WEST SUSSEX COUNTY COUNCIL CONSULTATION

TO:	Arun District Council FAO: Emma Sheppard
FROM:	WSCC – Highways Authority
DATE:	10 th April 2025
LOCATION:	Land at Oldlands Farm Newlands Road Bognor Regis PO22 9NN
SUBJECT:	BE/16/25/RES Approval of reserved matters following outline consent BE/150/22/OUT comprising of 3 No. units within Class B2 and/or B8 of the Use Classes Order (including ancillary office provision) with associated enabling works, parking, landscaping and sustainable drainage system with access off Newlands Road. This application is in CIL Zone 4 (Zero Rated) as other development.
DATE OF SITE VISIT:	Site known to officer
RECOMMENDATION:	Advice

PROPOSED
ACCESS

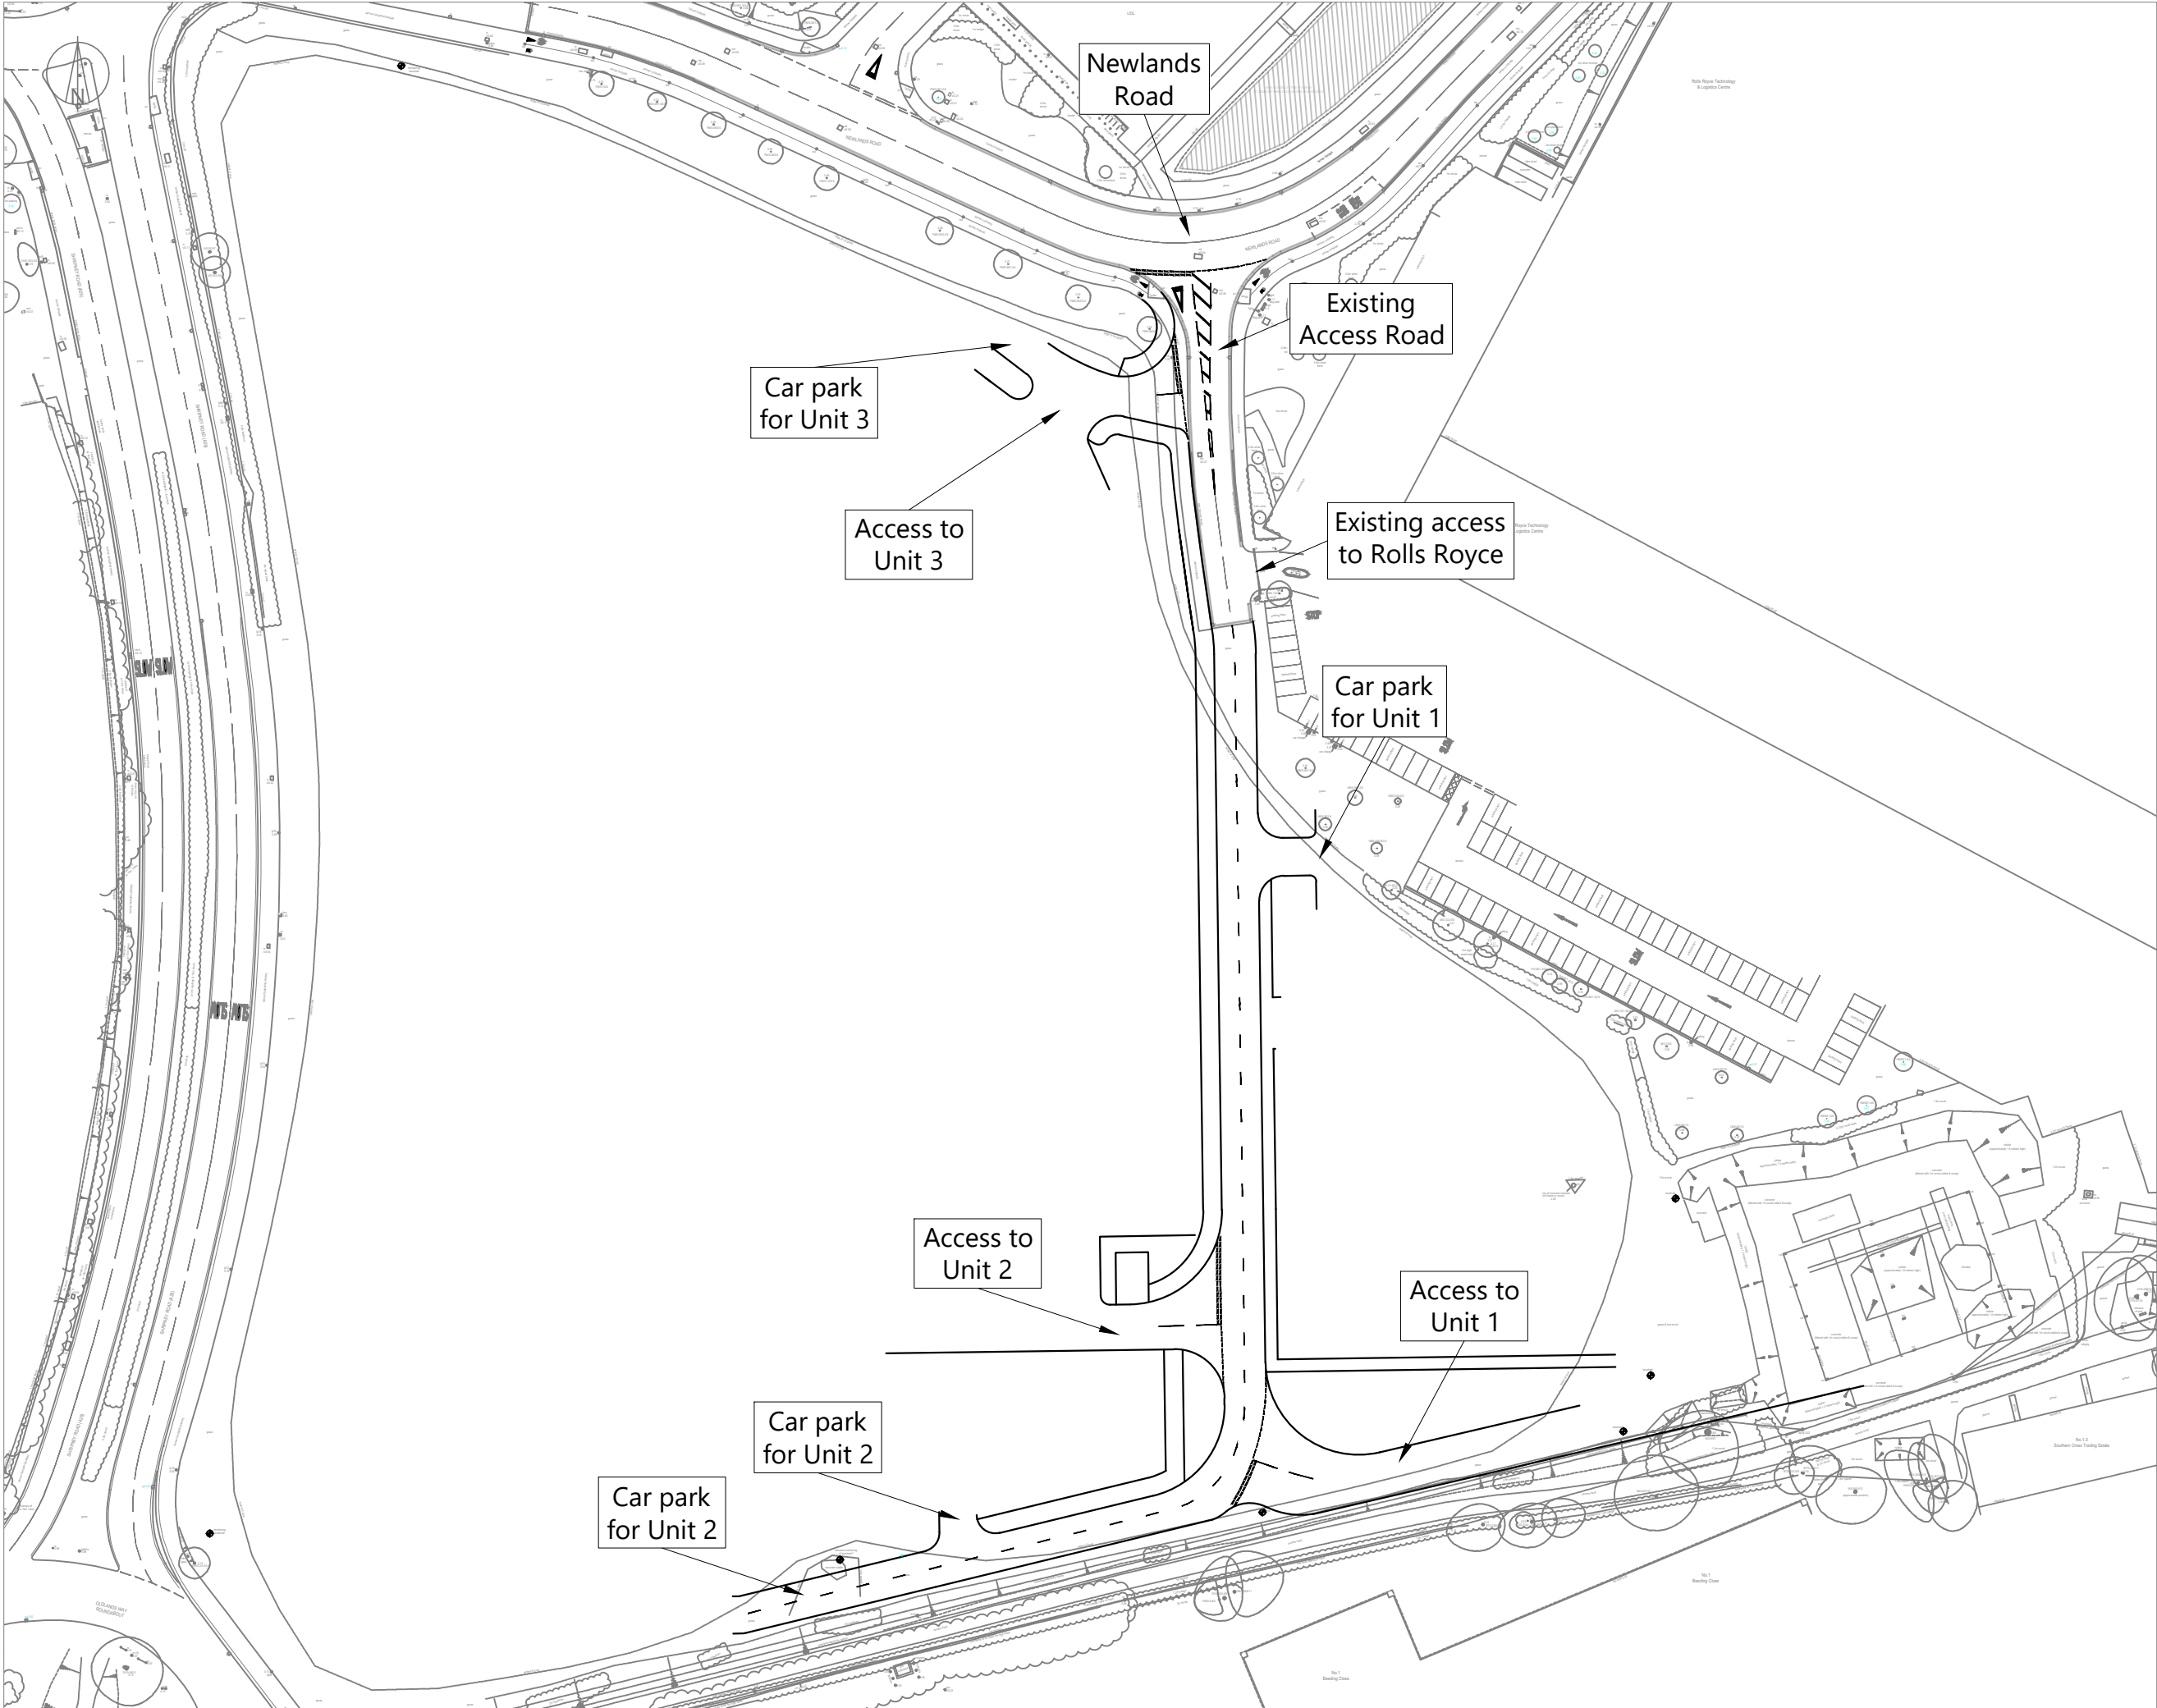
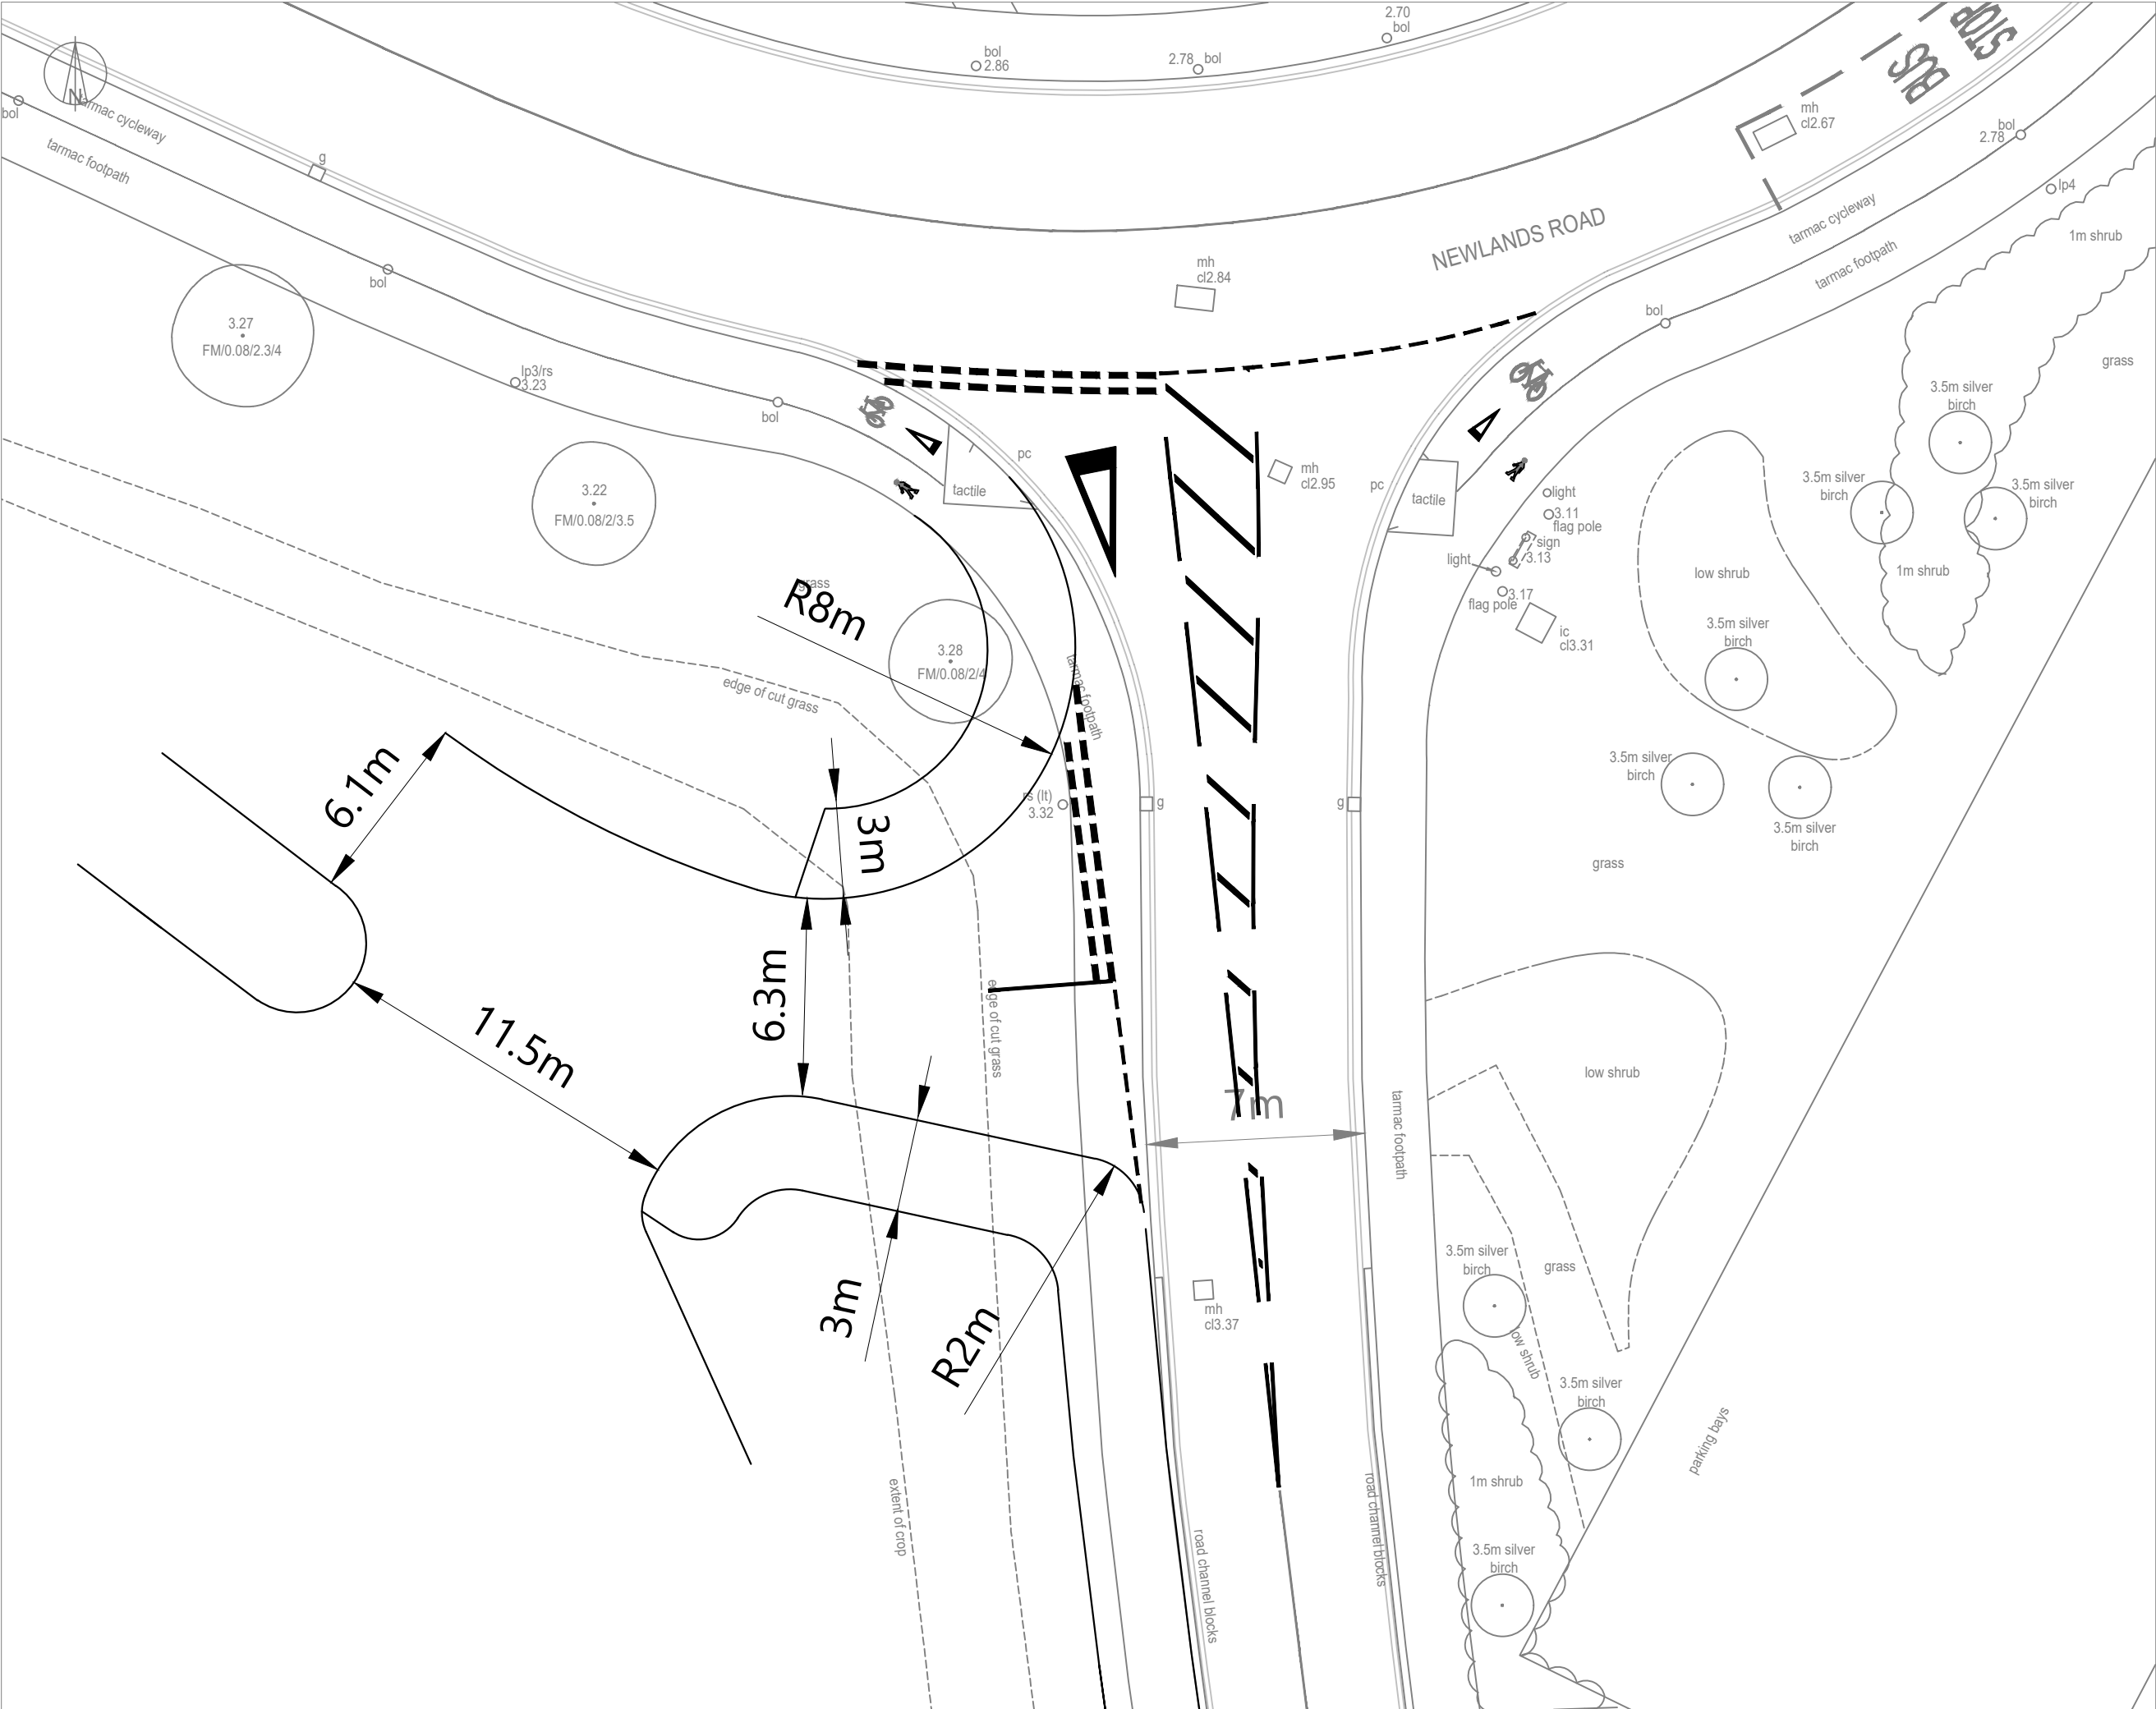
- Dropped tactile paving crossing points should be provided at each point of access across each access point. This does not appear to have been shown on the submitted drawings and should be added.

Subject to tactile paving being added at the access points the LHA is satisfied with the information submitted in of this RM application. A suitable condition has been added at the below to cover off this point.

No part of the development shall be first occupied until the road(s), footways, crossing points and casual parking areas serving the development have been constructed, surfaced, and drained in accordance with plans and details to be submitted to and approved by the Local Planning Authority.
